Our ref: DOC22/700418

Sender's ref: SSD-9726-Mod-1

Subject: Request for agency advice – Adaptive reuse of the Royal Hall of Industries - MOD 1 - staging and minor amendments (SSD-9726-Mod-1)

DEMOLITION PLAN
ROOF LEVEL

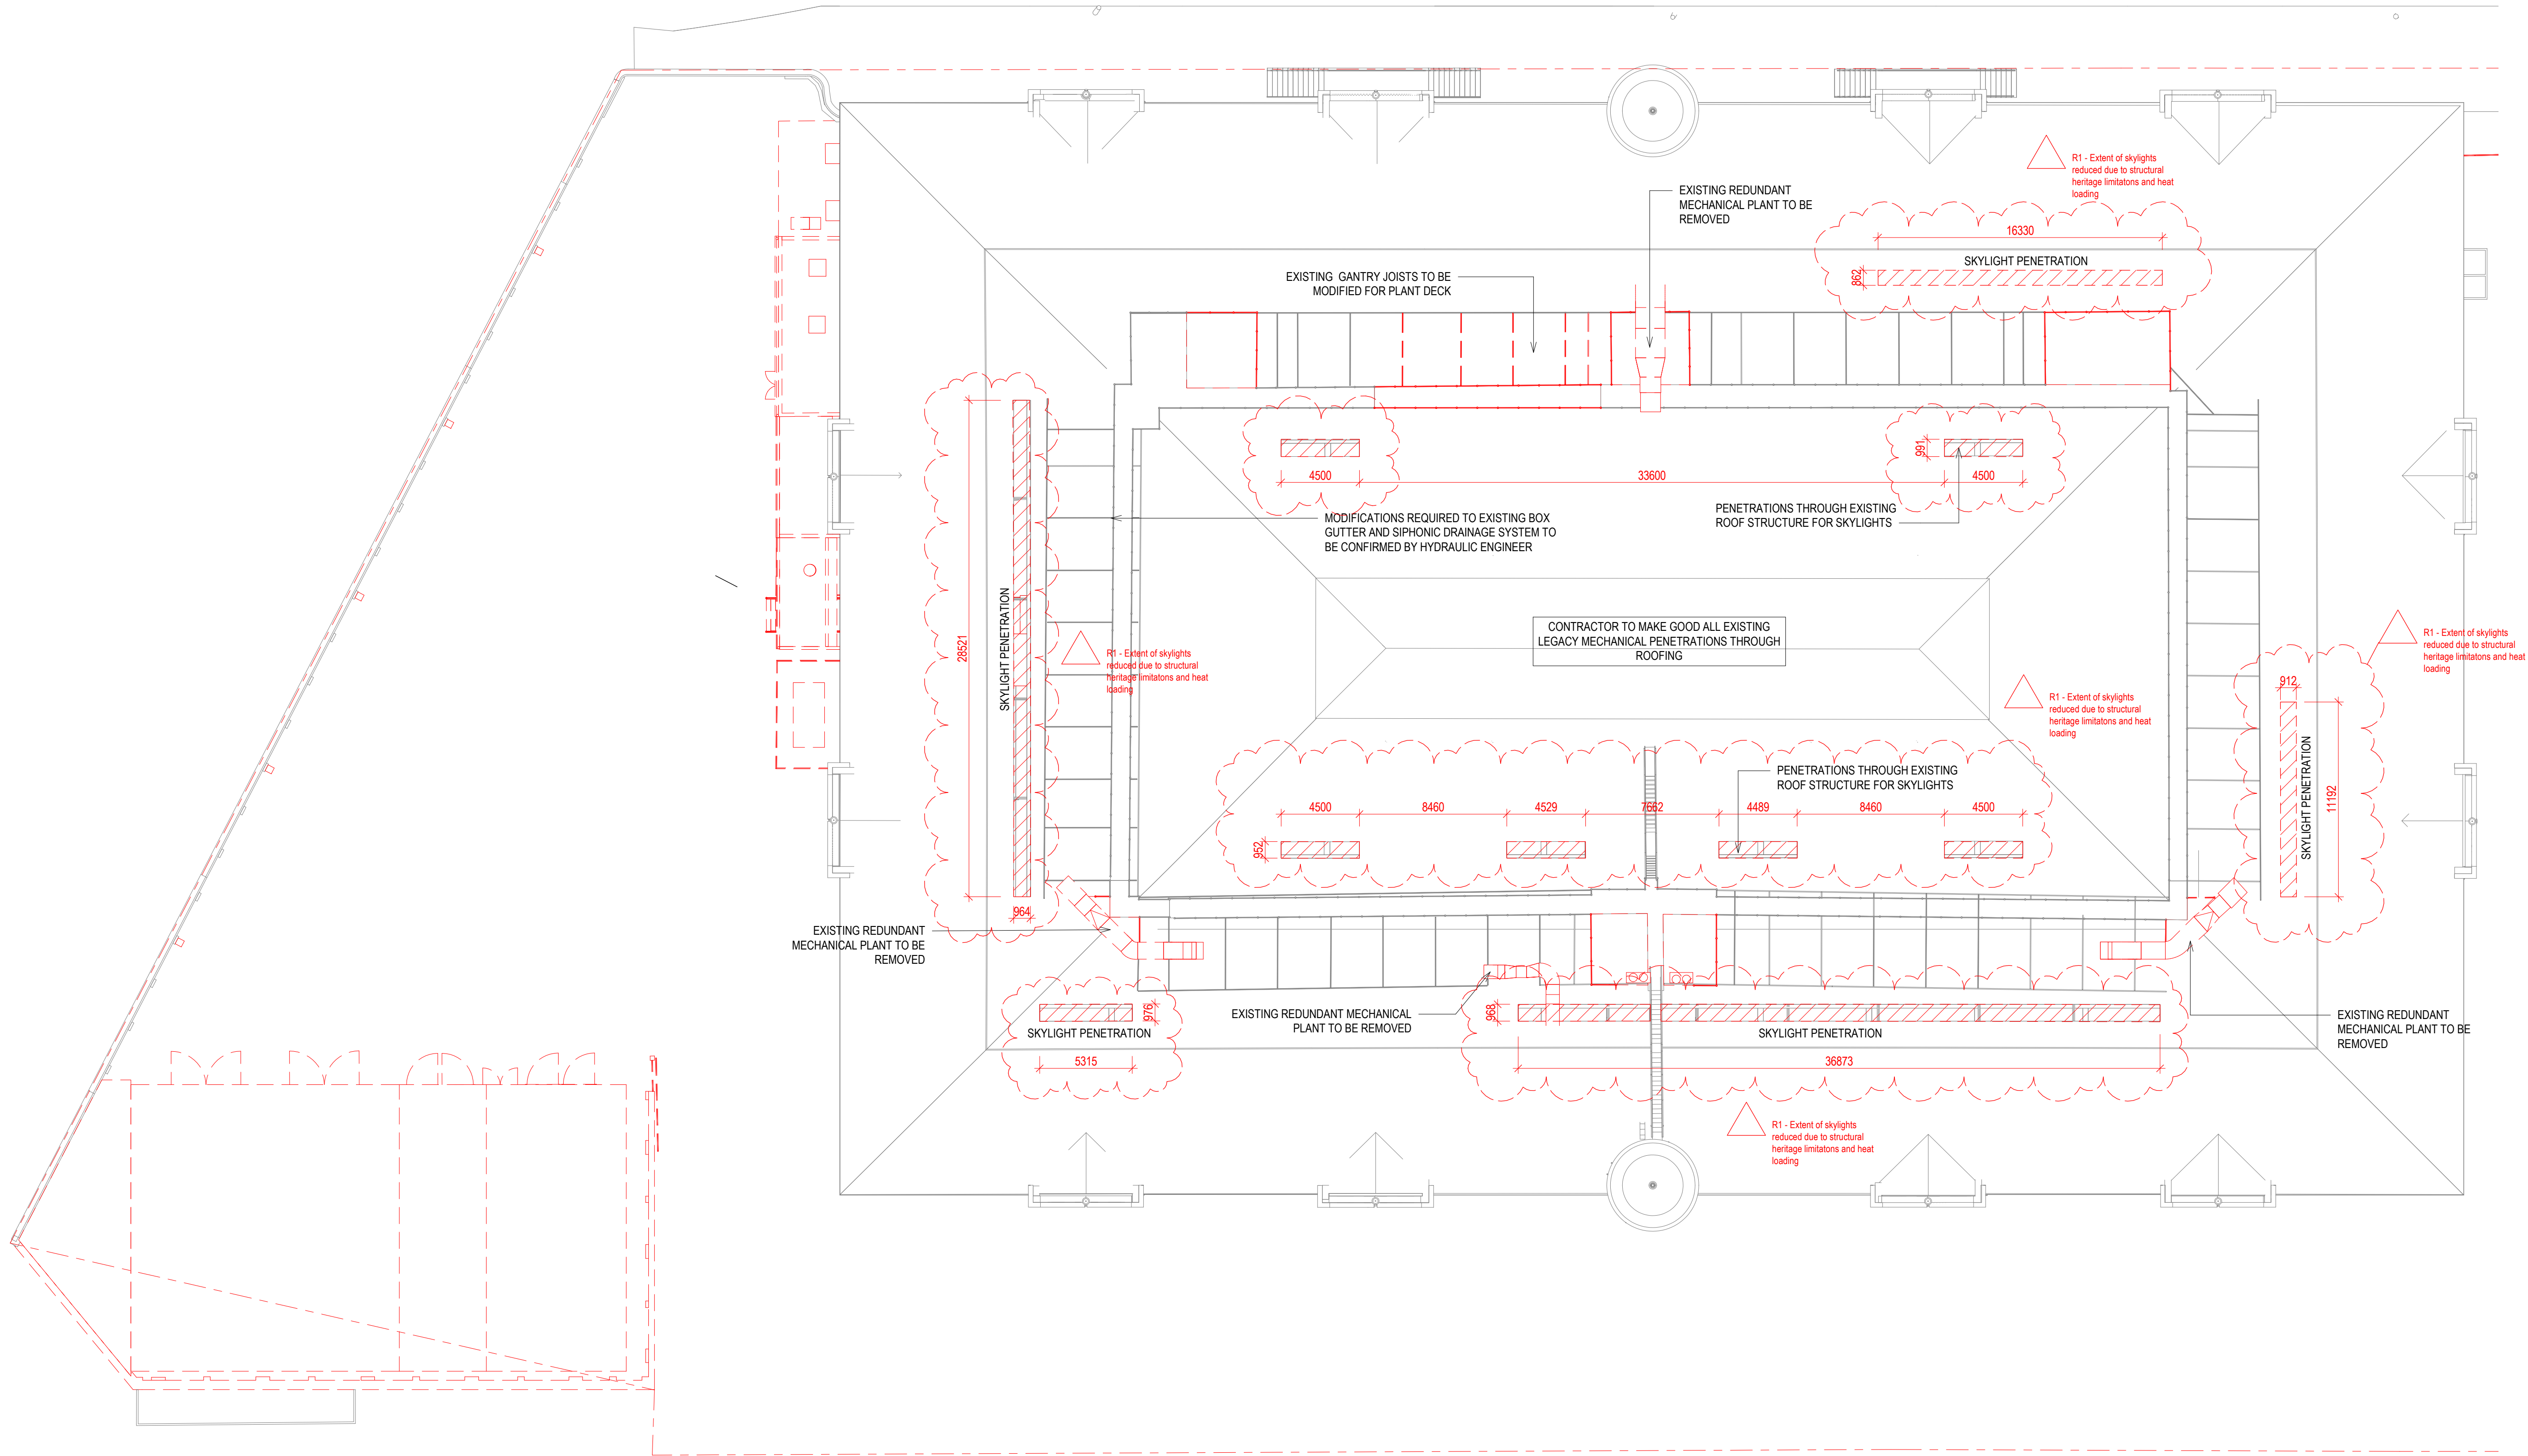
EHG notes that the Modification report proposes to retain some of the existing roof structure, rather than undertake full replacement as approved. Therefore, EHG assumes that the impacts on microbat roosts will also be less likely. However, it is not clear whether the Modification report has been prepared in the knowledge that microbats roost in the roof cavity. It is also not clear if all potential impacts have been considered. If there is any doubt about microbat impacts from the Modification, EHG recommends advice is sought from a suitably experienced ecologist.

EHG also notes the microbat survey recommended that "*the Microbat Management Plan is updated to reflect the findings of the (2021 survey) report and the revised scope of works that will no longer include a complete roof replacement. This will include retention of suitable roosting spaces that allows for Large Bent-winged Bats to continue using the site as an occasional roost once works are complete.*"

EHG recommends that the above updates to the Microbat Management Plan be undertaken to inform the assessment of the proposed modification.
